Our Ref: PR115191-1
Your Ref: SSD-4972
Date: 26 October 2012

**RE: SUBMISSION TO DEVELOPMENT APPLICATION (REF: SSD-4972)
FOUR POINTS BY SHERATON HOTEL EXPANSION
161 SUSSEX STREET, SYDNEY**

The development application (Ref: **SSD-4972**) is currently on exhibition until Friday 26 October 2012. The proposal comprises the construction of a 25 storey tower at the southern end of the site which will include 231 new hotel rooms on levels 1 to 14, seven storeys of new commercial office space on levels 16 to 22 and two plant levels.

JUN 21 9AM

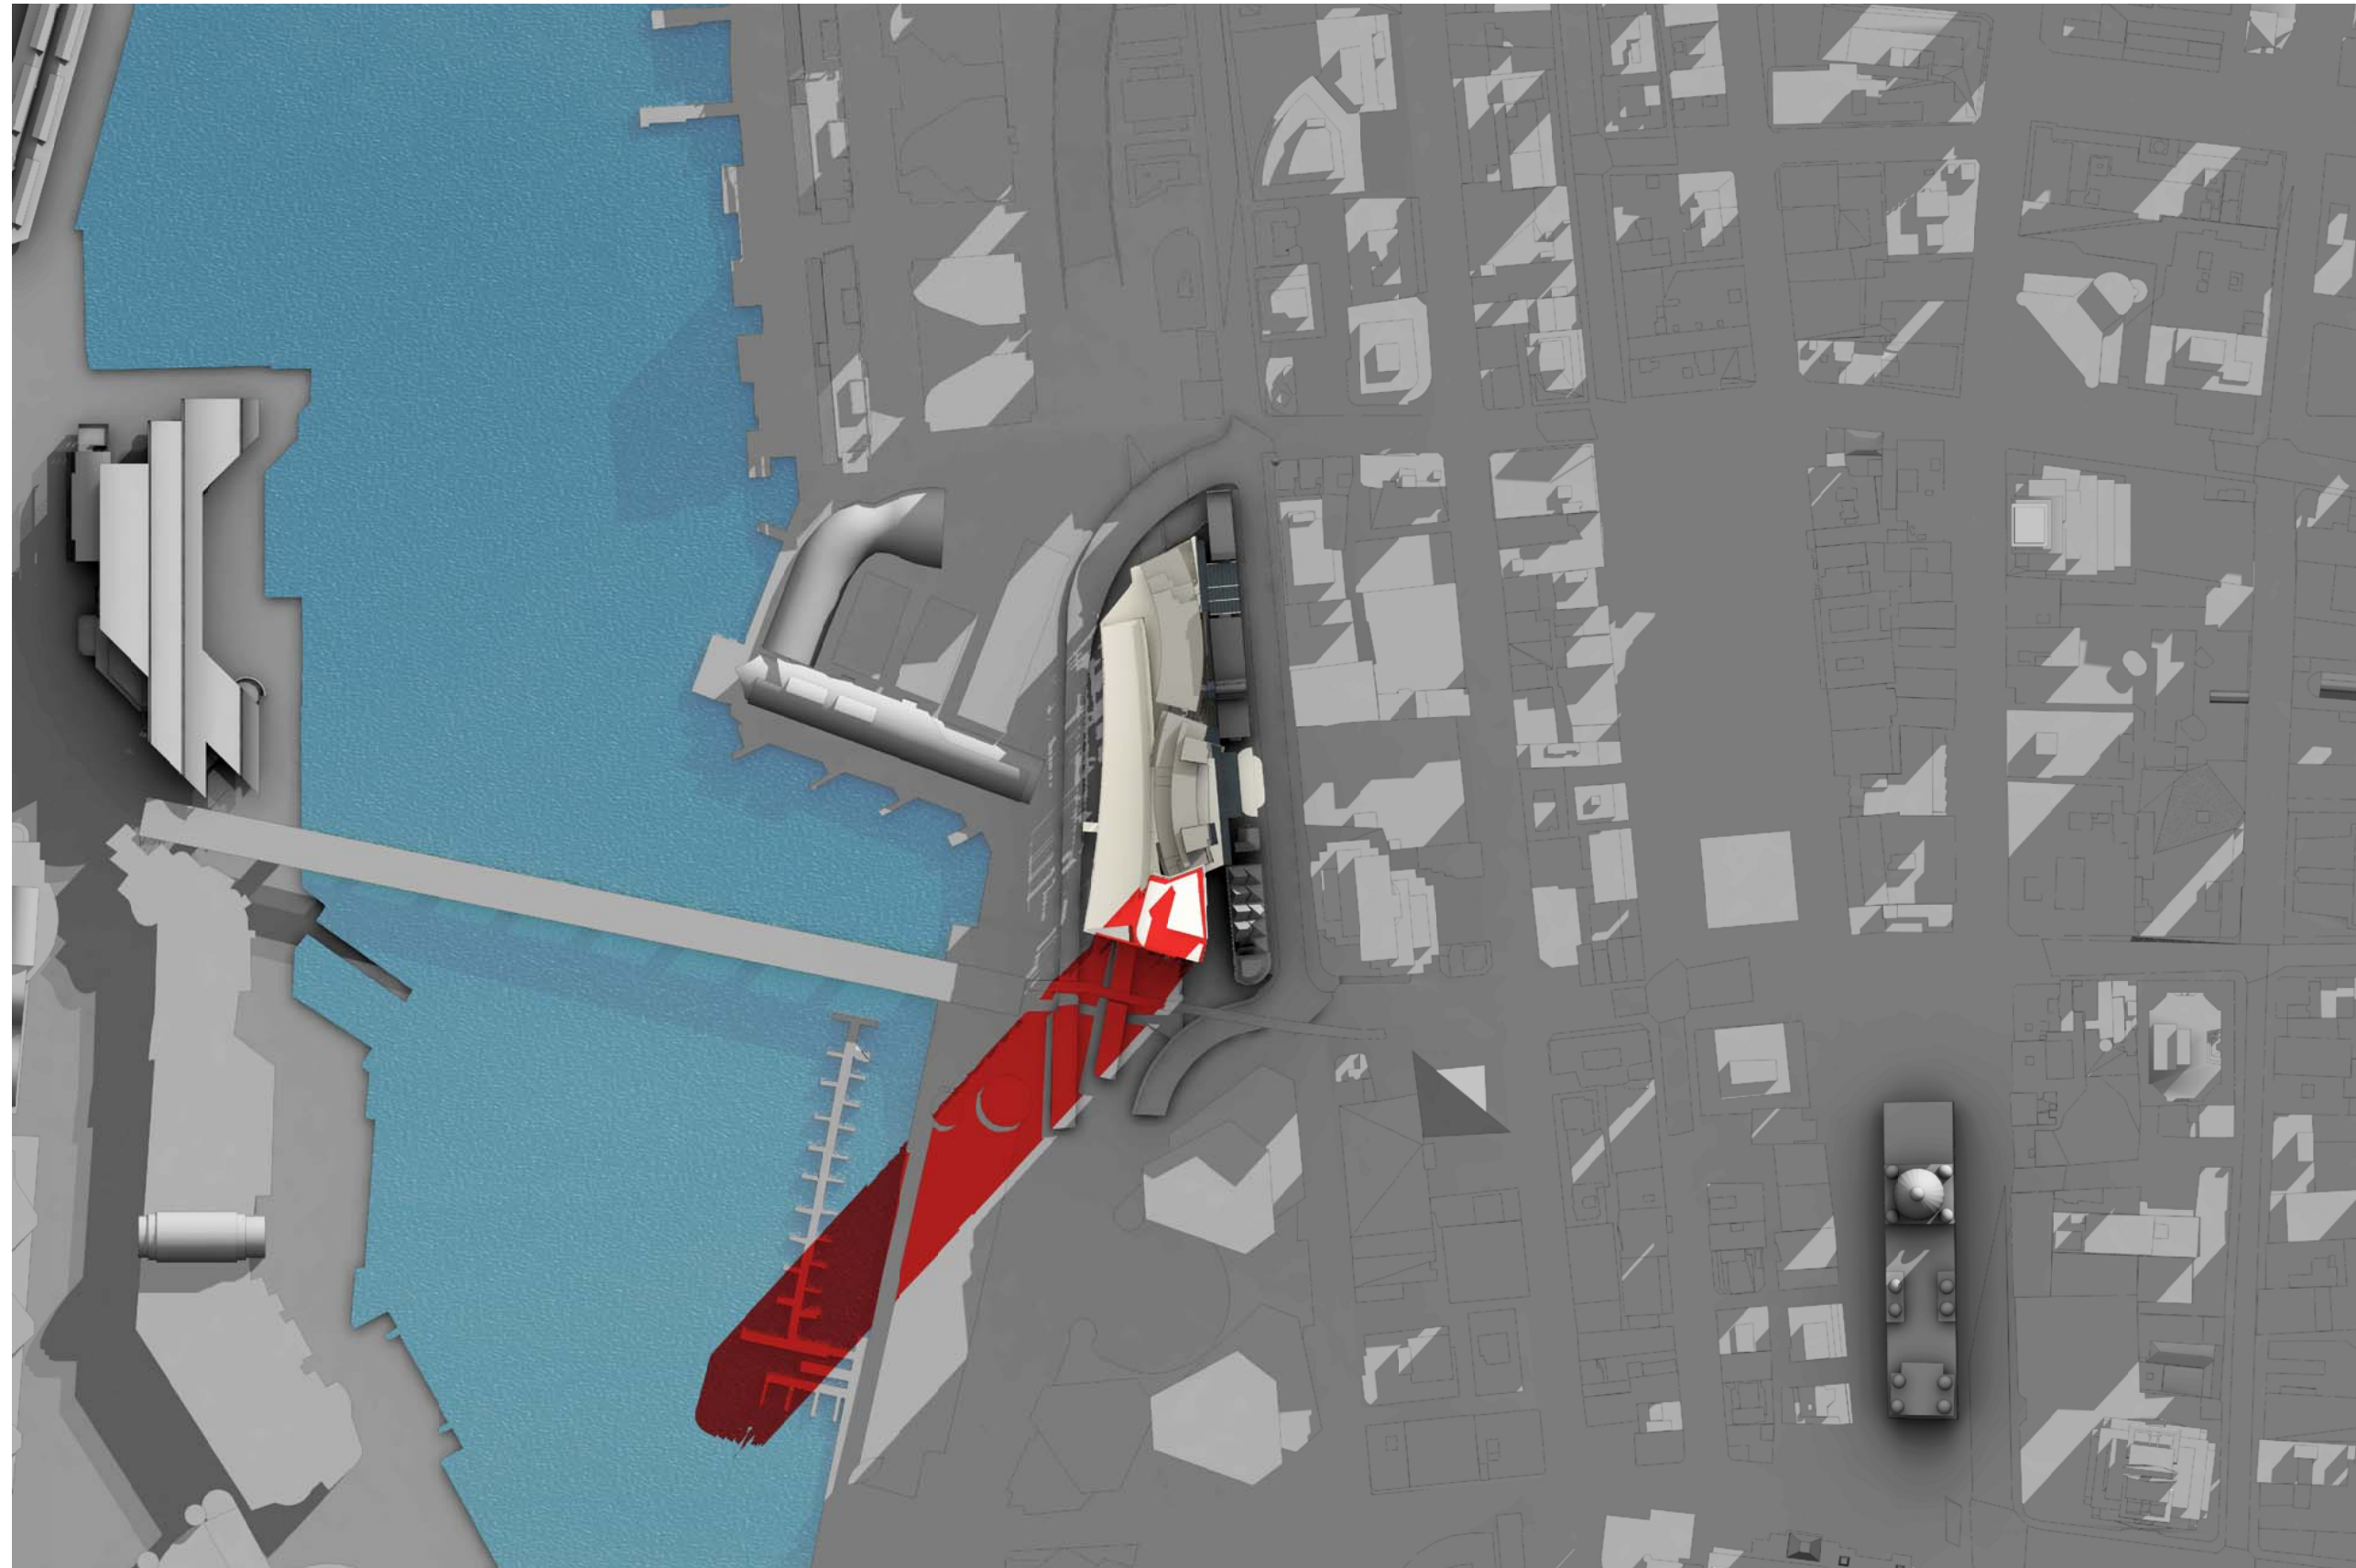
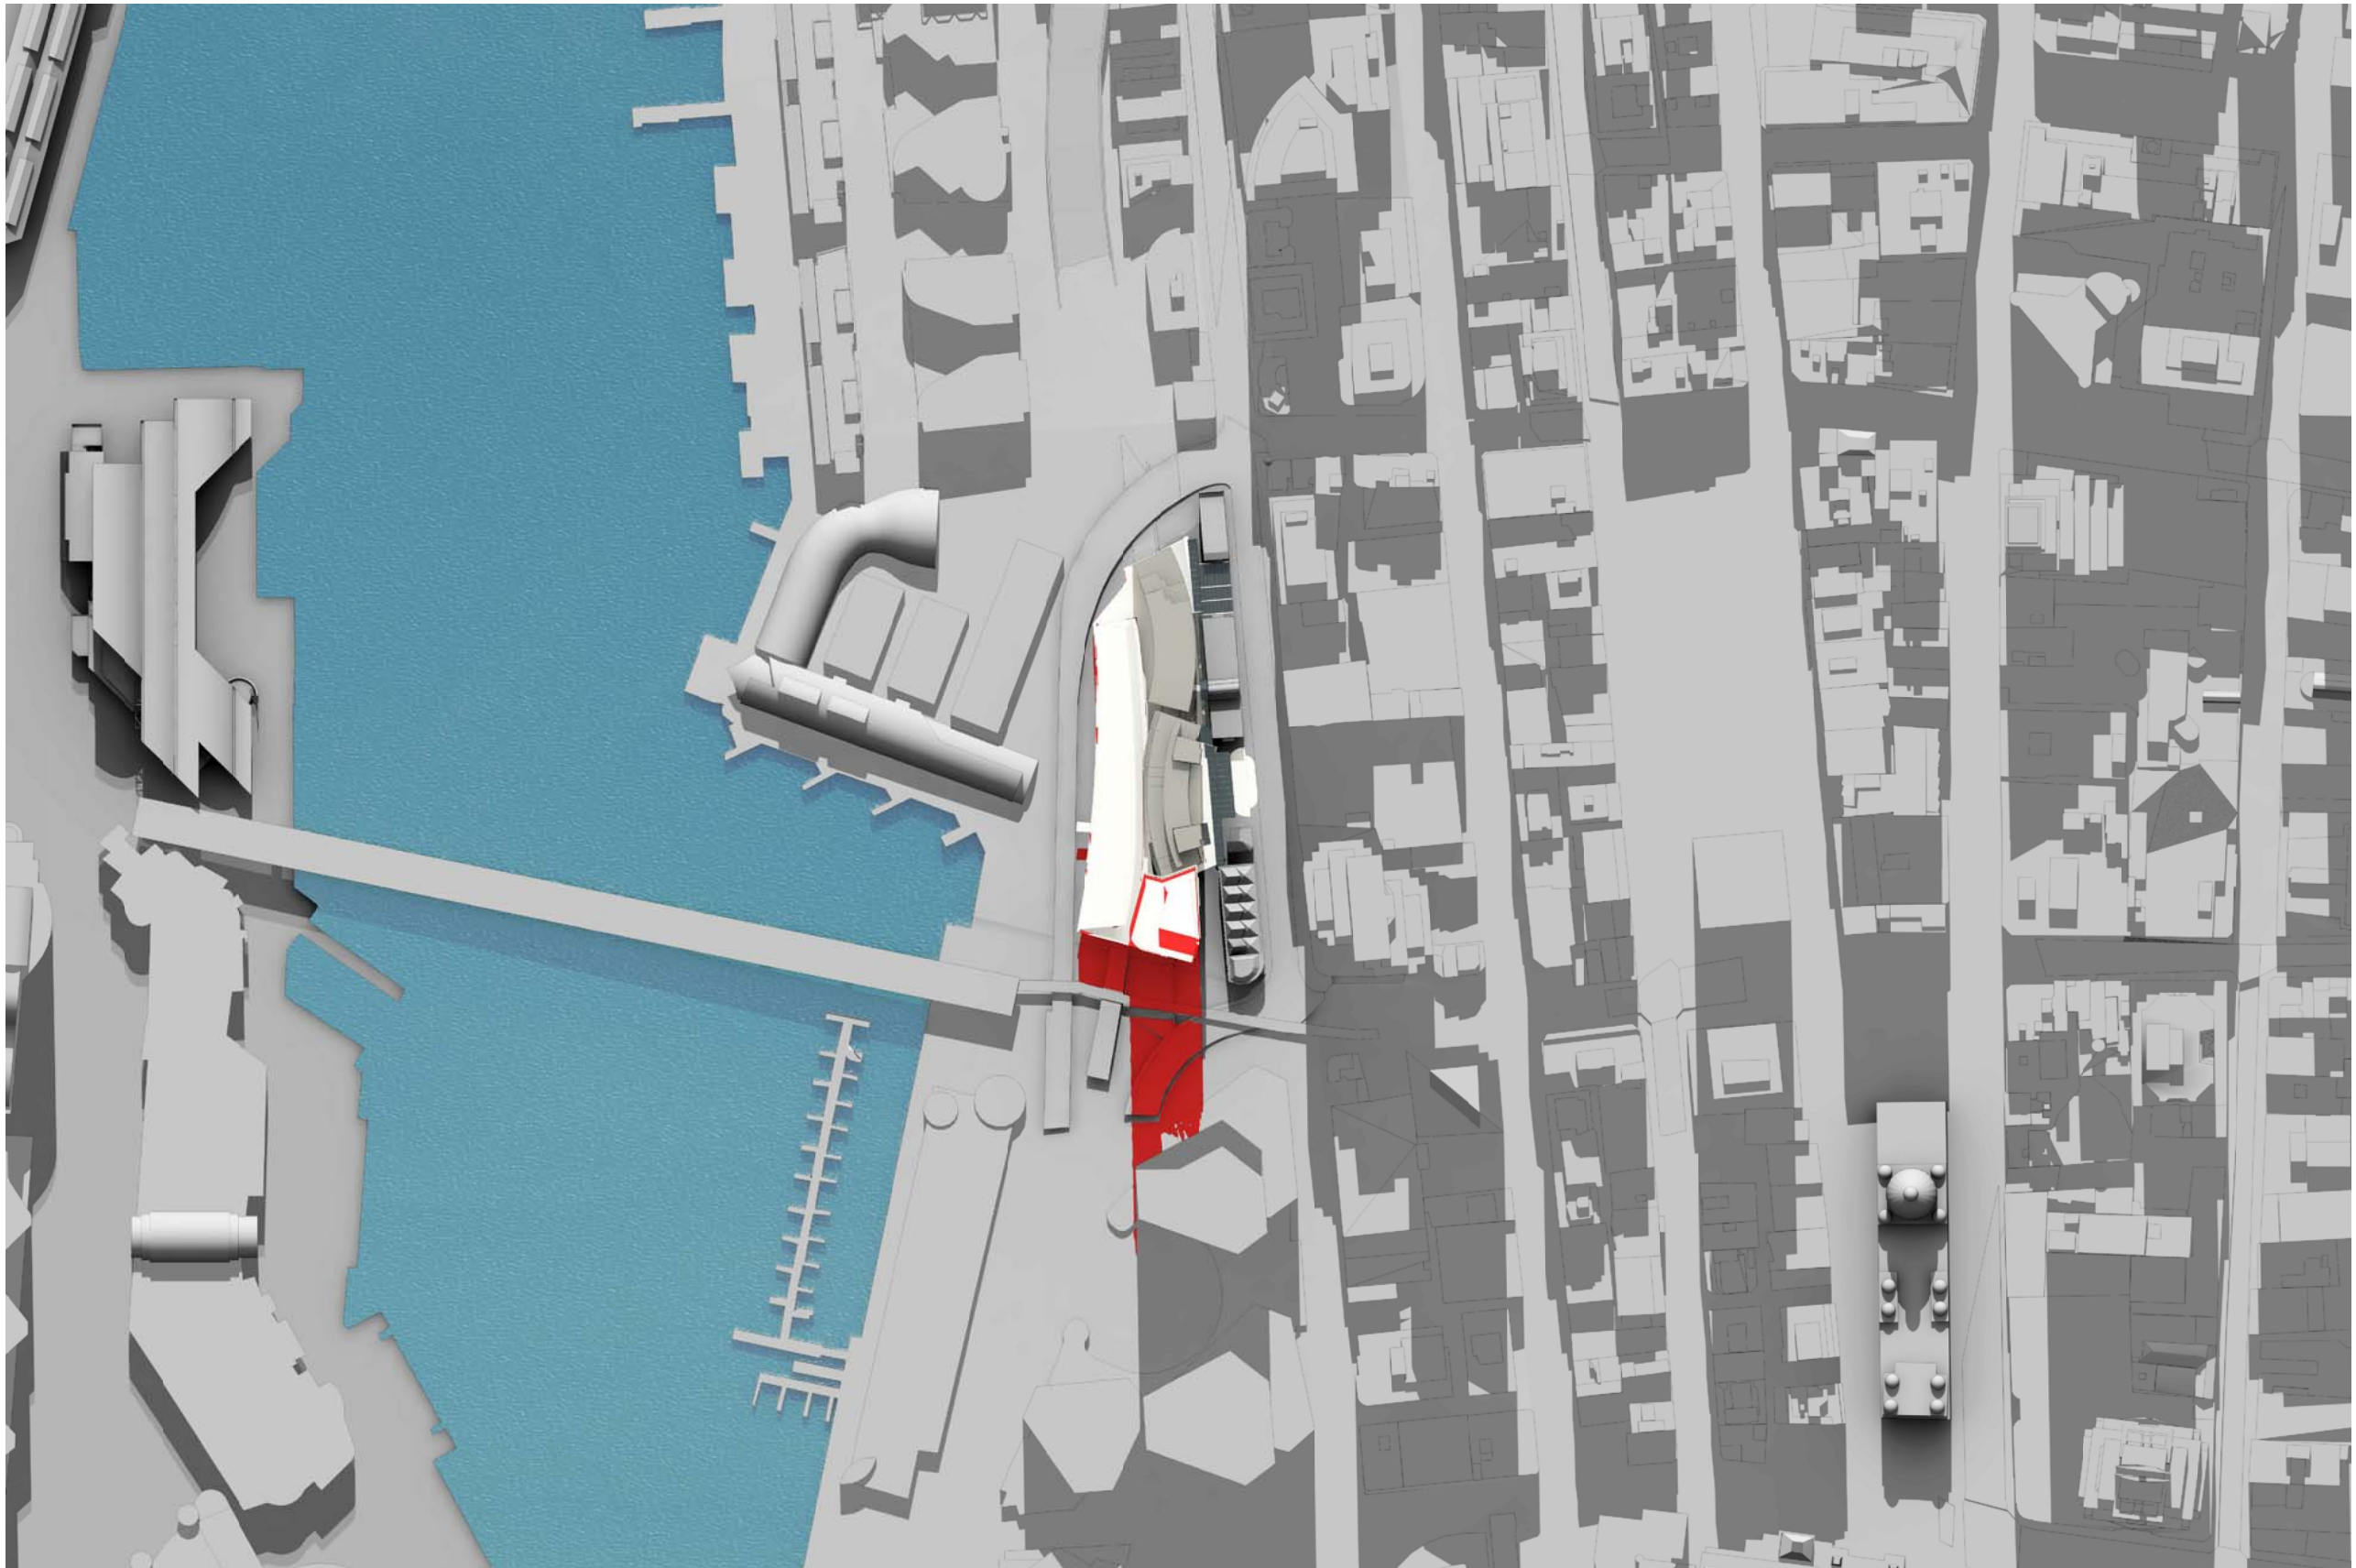
The solar study prepared by Cox Richardson identifies that the proposal will result in significant overshadowing over Darling Harbour to the south east on June 21 at 9am and west on December 21 at 9am. The study demonstrates the proposal will overshadow the Darling Harbour waterfront pedestrian area during the morning throughout the year (refer below).

Darling Harbour is an important Sydney icon. The level of overshadowing that would be caused by the proposed development in its current form in this area is considered unreasonable.
